Rezoning Transportation Analysis

Petition Number: 2020-125

General Location Identifier: Tax ID 05112203

Date	Description
10-26-20	First Review
11-30-20	Second Review

**RZ-1.0**

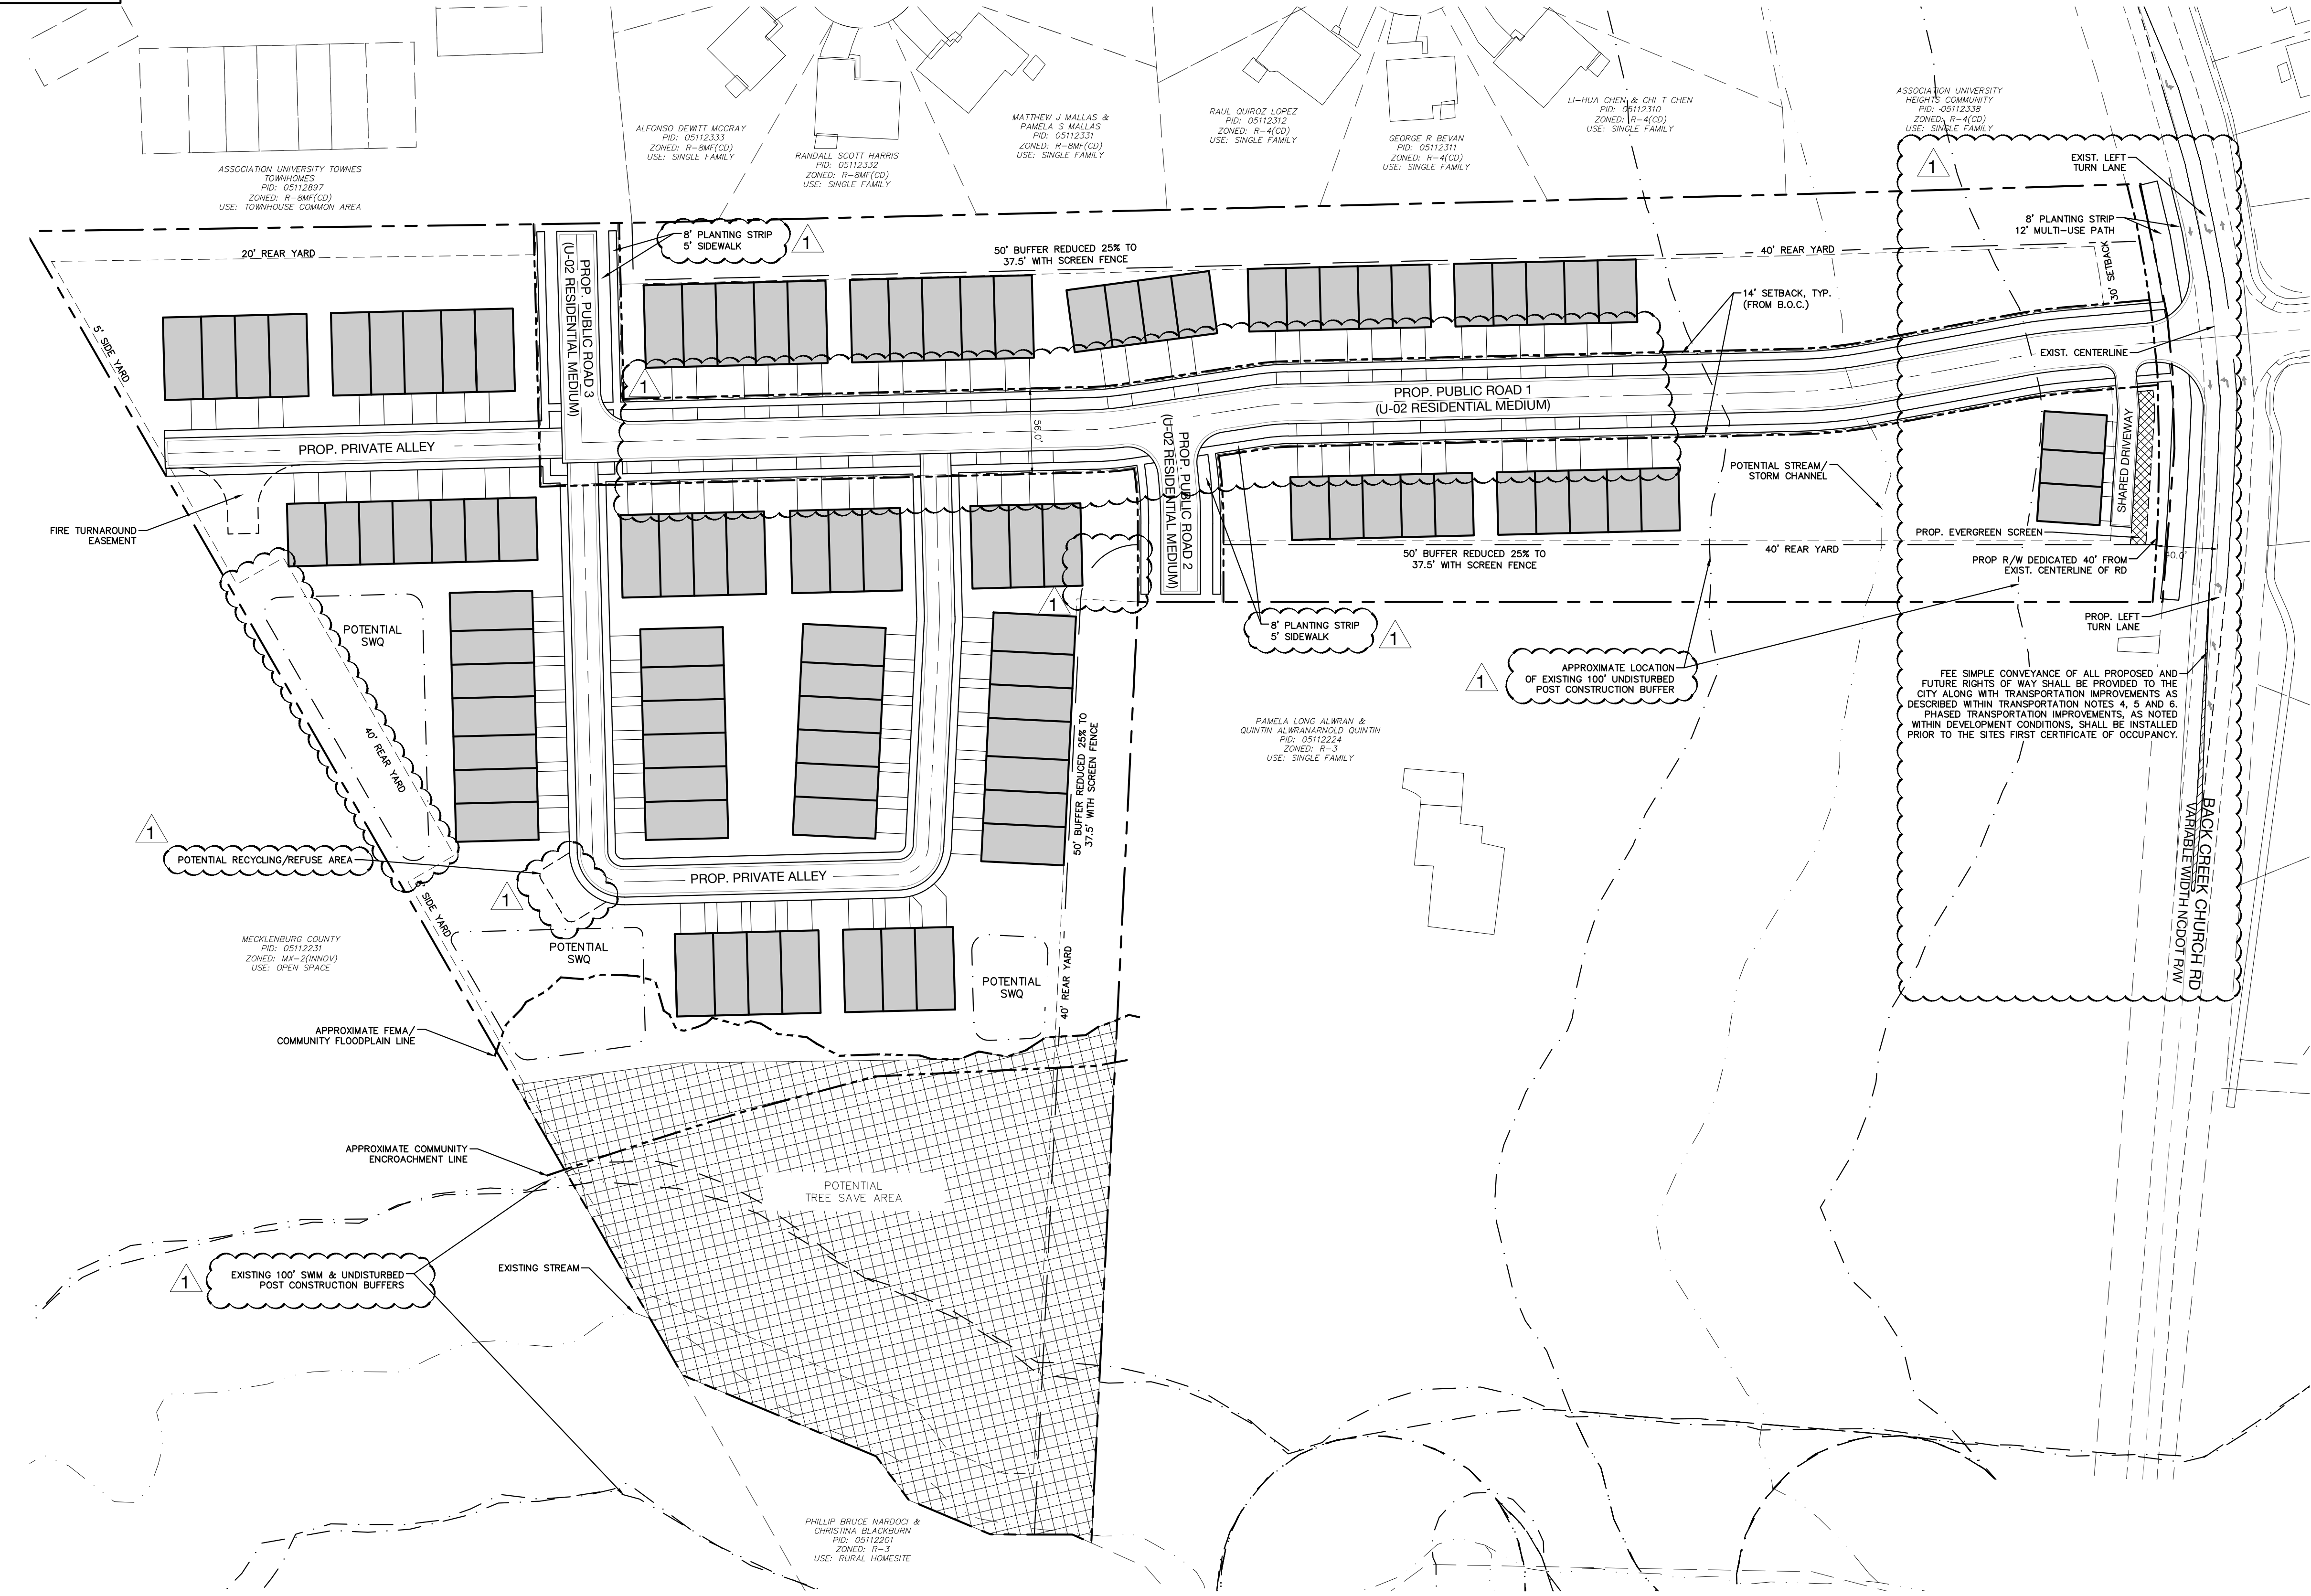
1. **Curblines:** ~~The proposed zoning district has a setback measured from back of the existing or proposed future curblines.~~
 - a. ~~**Back Creek Church Road:** The back of curb and gutter shall be located at 19' from the roadway centerline. This accounts for two 11' through lanes, 2.5' curb and gutter, and an 11' left turn lane at the site's entrance.~~

The site plan should show the curb and gutter labeled and dimensioned from the centerline for each road.
2. **Traffic Study:**

3. ~~Revise the site plan and conditional note(s) to commit to dedicating 40' minimum right of way from the Back Creek Church Road centerline. The site plan shall label and dimension the right-of-way from the road centerline.~~

4. ~~Revise the site plan and conditional note(s) to commit to constructing an 8-foot planting strip, and 6-foot sidewalk on all Local roads per Chapter 20 and CLDSM Standard U-03. While the site plan shows both, they need to be labeled and dimensioned accurately from the back of curb and gutter.~~

5. ~~The site plan and conditional note(s) revisions are needed to commit to installing a 12' multi-use path along Back Creek Church Road to meet the City Charlotte BIKE Policy.~~

6. ~~Revise the site plan and conditional note(s) to commit to providing a left turn lane into the development as required for developments that generate over 500 trips per day, as per NCDOT's policy on street and driveway access.~~

- ~~7. The proposed driveways do not meet the minimum spacing requirement of 20' per the City of Charlotte Driveway regulation. Revise site plan and conditional note(s) to commit to constructing alley loaded homes along public roads **OR** provide shared access driveways to help produce a more organized and pedestrian oriented form of access management per the City of Charlotte Driveway Regulation.~~
